Subject: FW: Planning Consultation on: Y/15/21/DOC Land North of Yapton Primary School

From: Laura Gibbons <Laura.Gibbons@arun.gov.uk>
Sent: 09 March 2021 11:58
To: Planning.Responses <Planning.Responses@arun.gov.uk>
Cc: Simon Davis <Simon.Davis@arun.gov.uk>
Subject: RE: Planning Consultation on: Y/15/21/DOC

Condition 9- surface water drainage strategy

Drawing Title
**DRAINAGE CONSTRUCTION
DETAILS (SHEET 2 OF 2)**

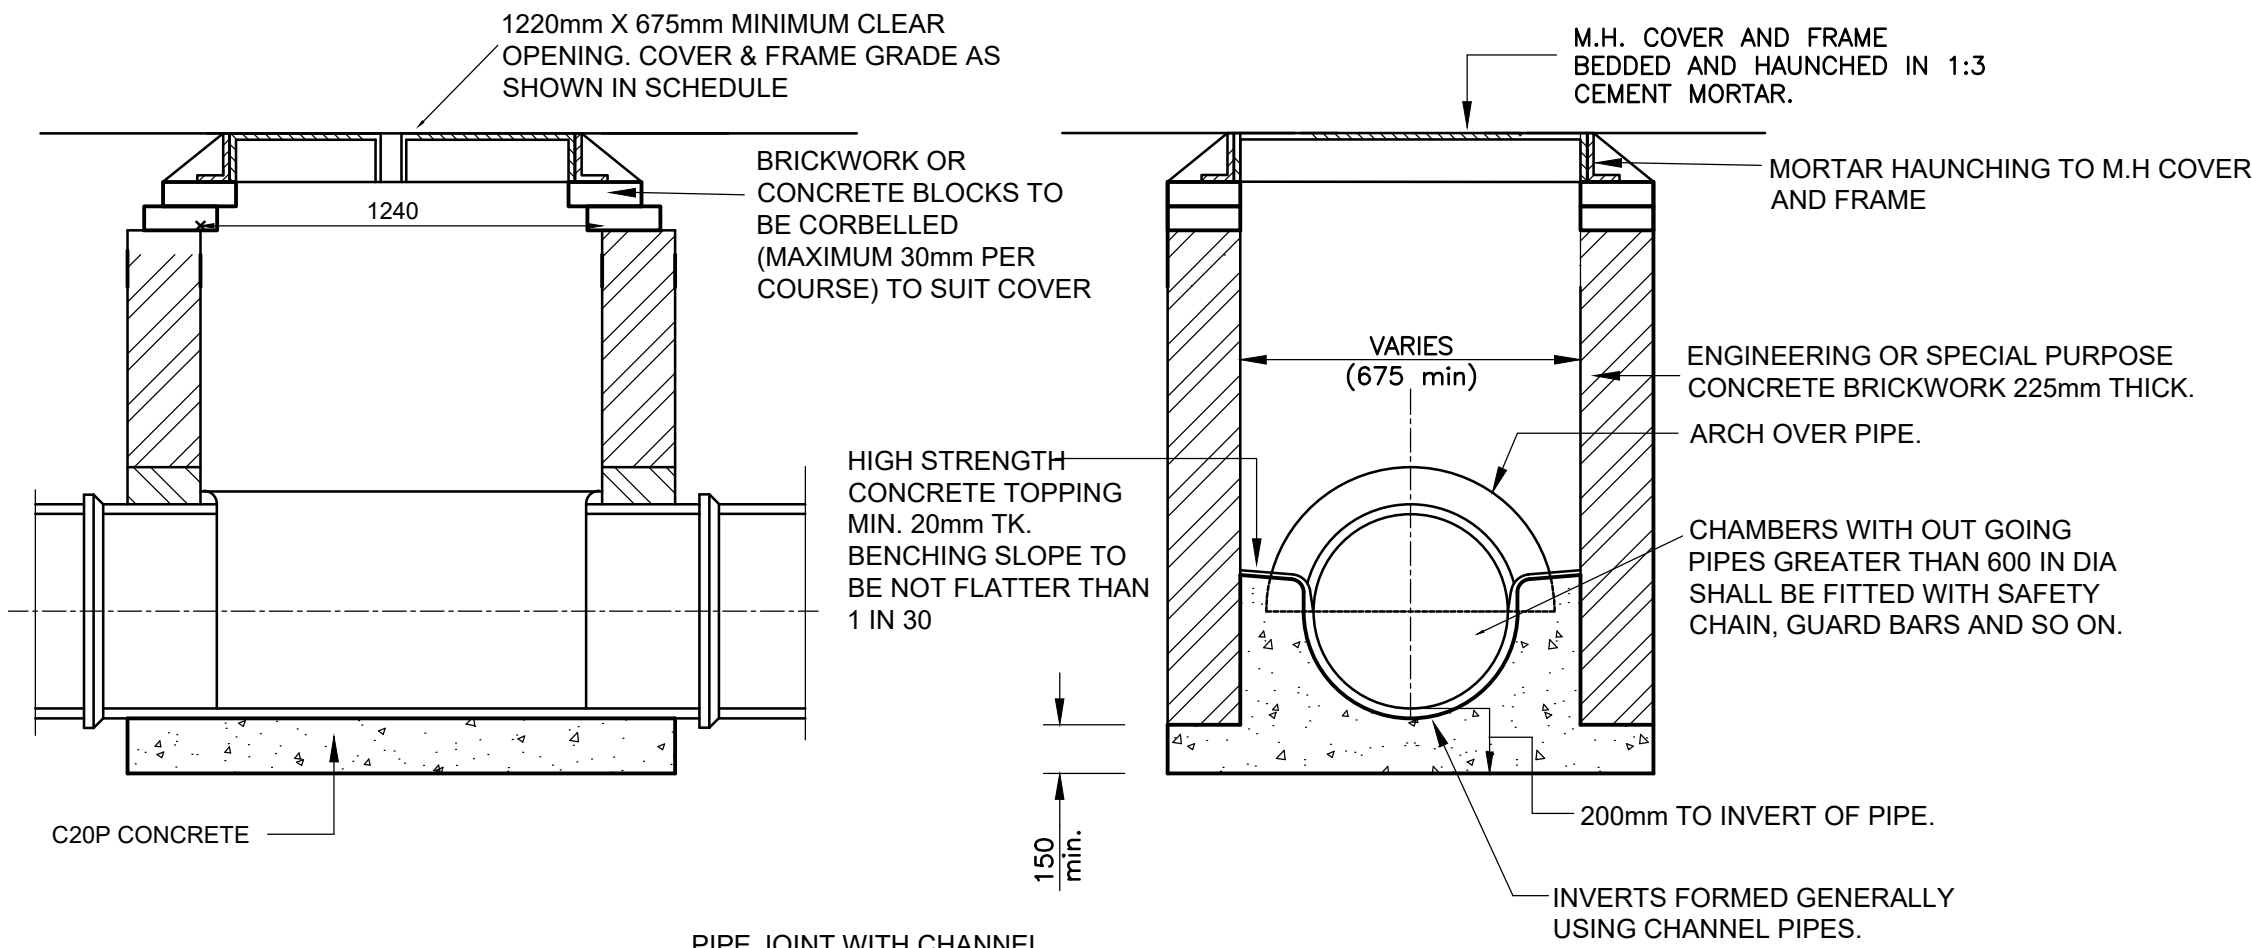
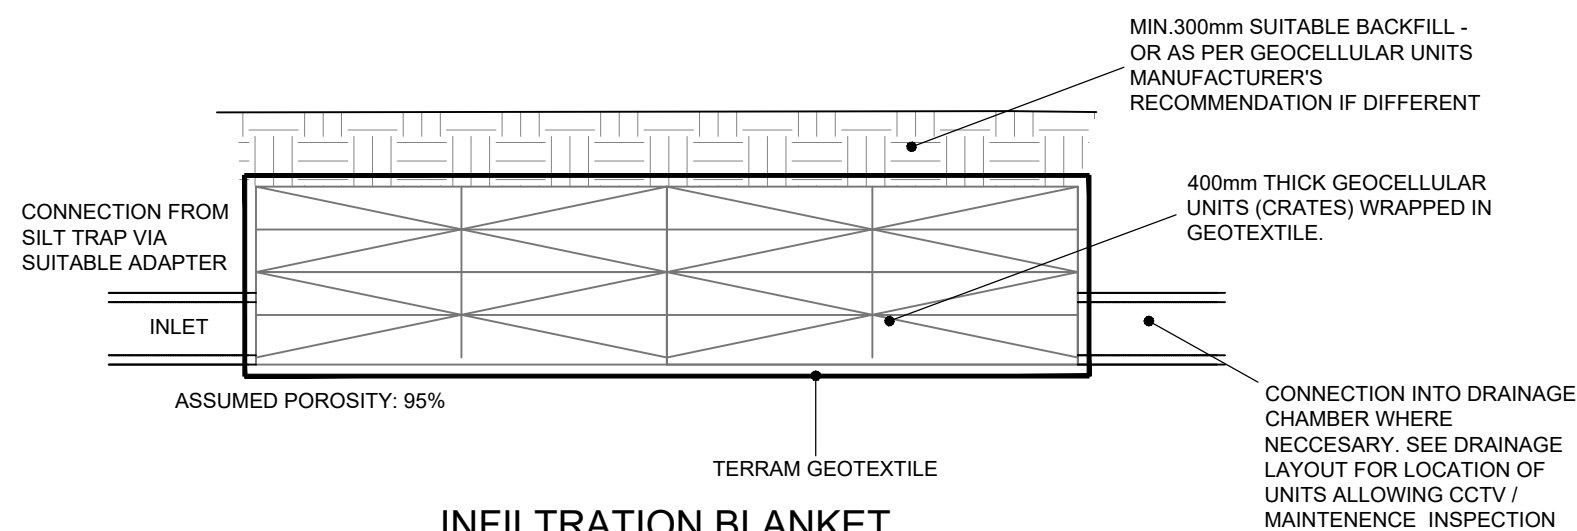
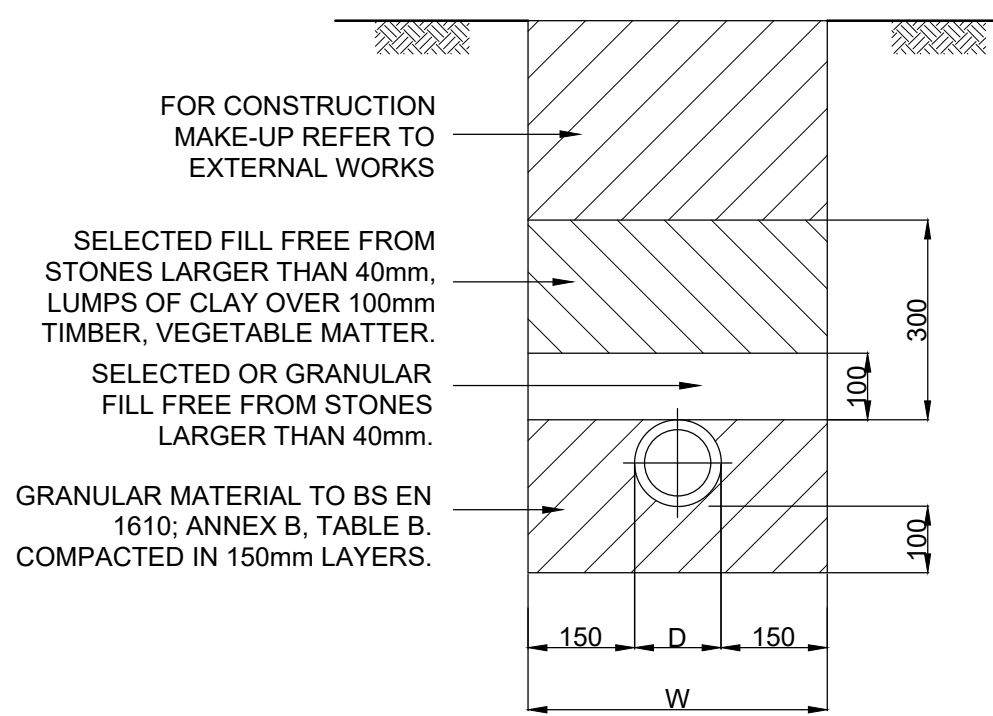
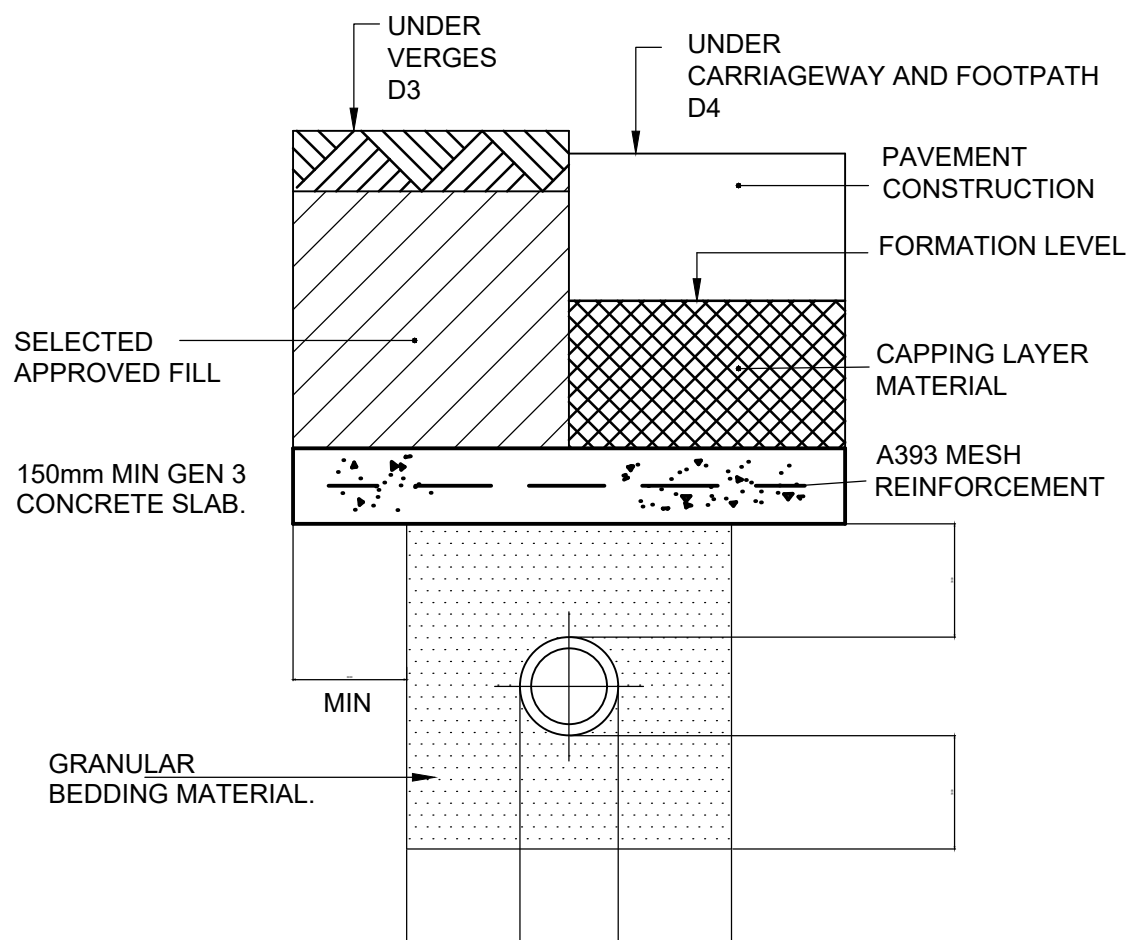
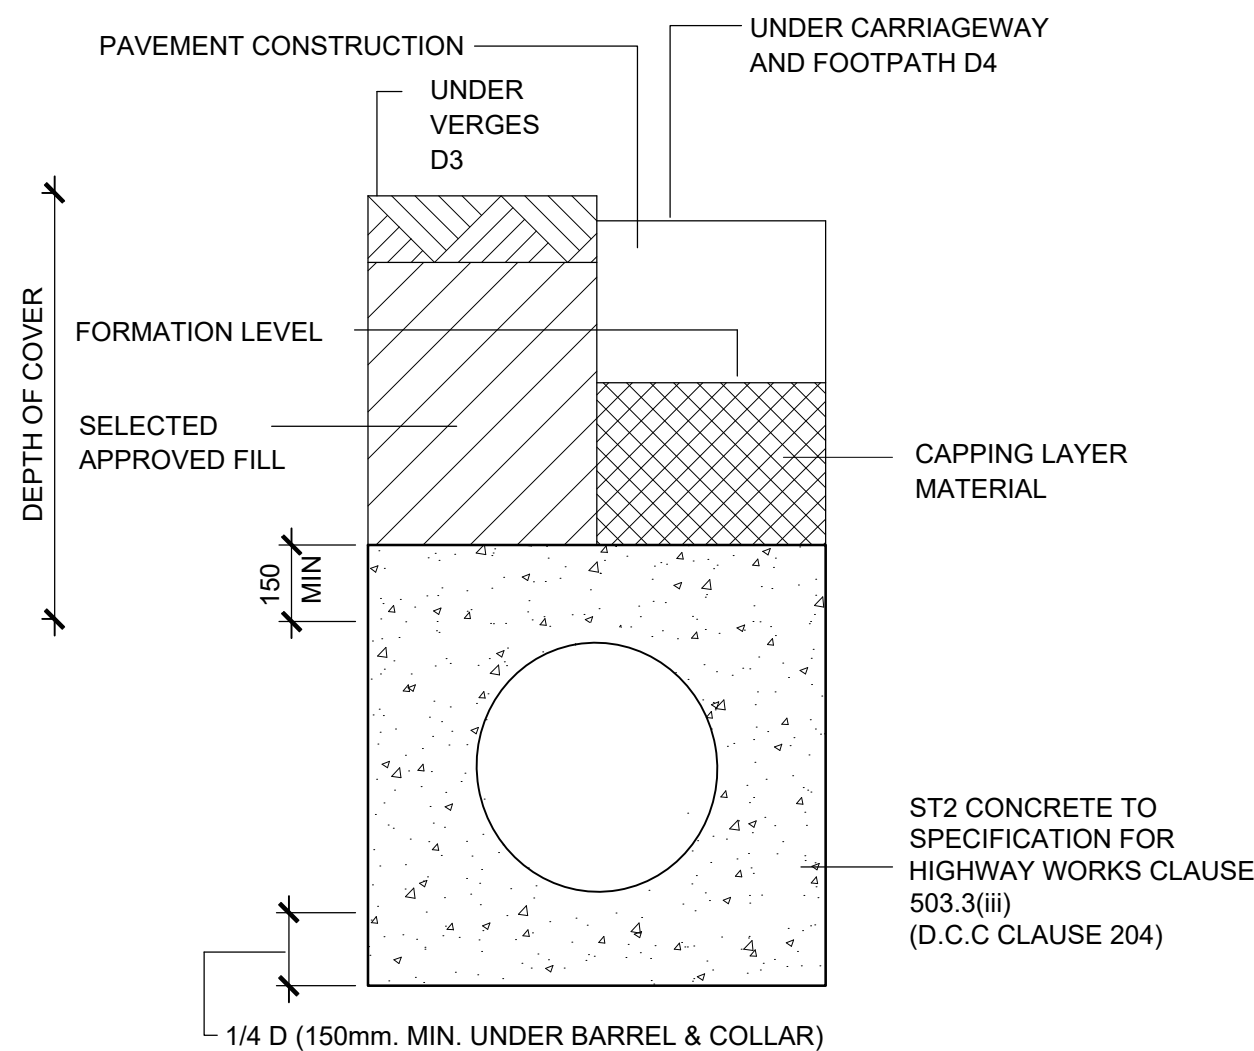
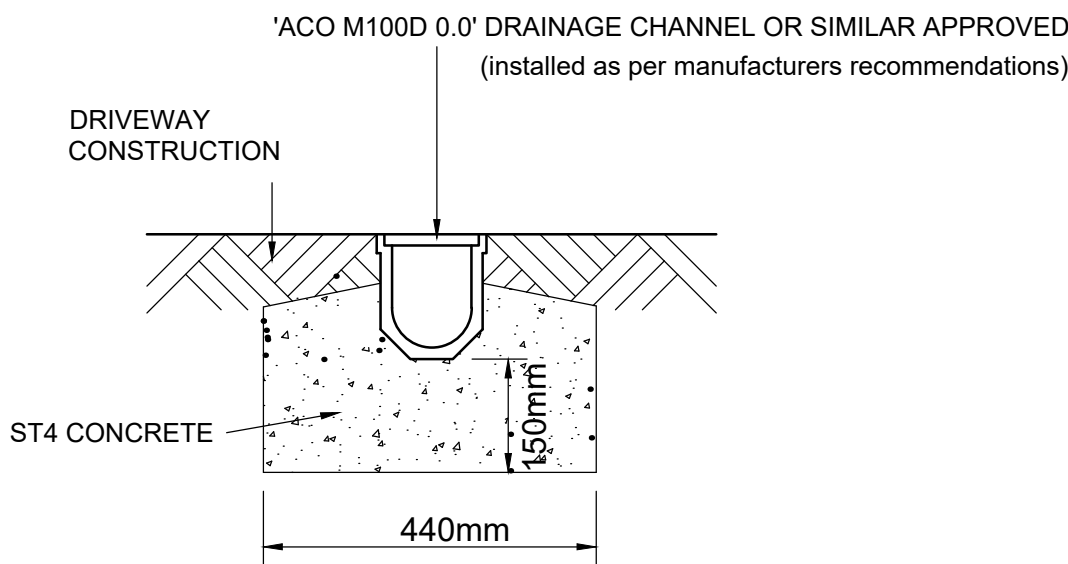
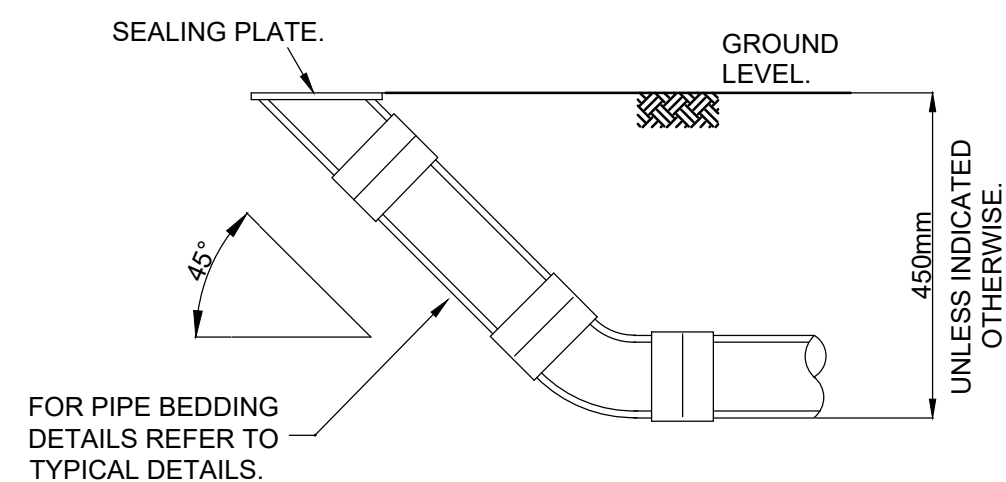
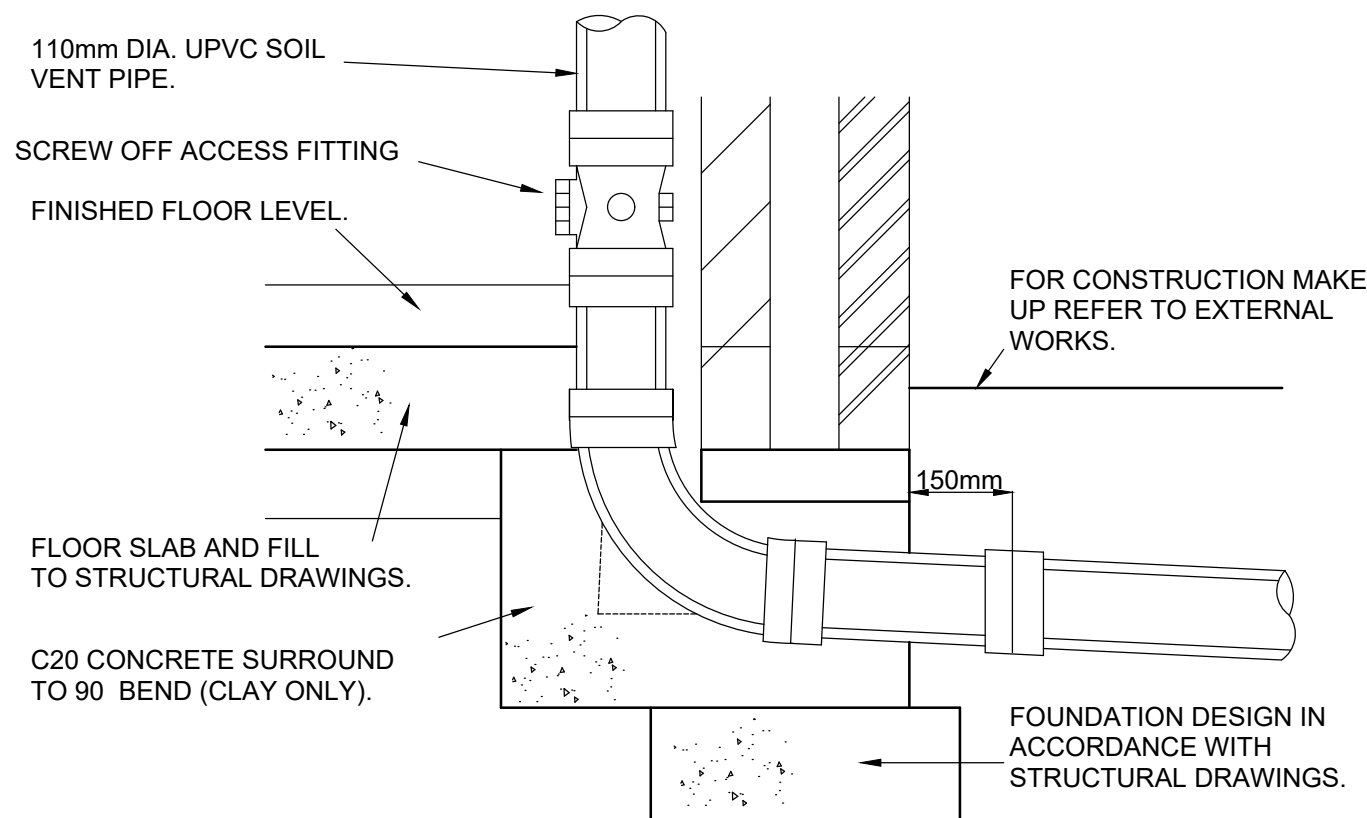
6. Please specify sand bedding and surround to infiltration blankets. Bedding layer specification provided on drawing YAP-180-031C2. *Okay, point closed.*

7. Please identify on construction details of infiltration blankets that invert level is to be as per drainage layout drawings. Currently you are showing incoming pipes at the base of crates. Infiltration blanket detail adjusted as requested. Please see drawing YAP-180-031C2. *Okay, point closed.*

8. Please remove irrelevant construction detail drawings, e.g. hybrid infiltration blankets, infiltration blankets with overlying infiltration basins, and gully grating within infiltration basin. Construction detail drawing updated - please see drawing YAP-180-031C2. *Okay, point closed.*

13. Please provide a construction detail which shows connections into permavoid crates. Construction detail drawing updated - please see drawing YAP-180-031C2. *Okay, point closed.*
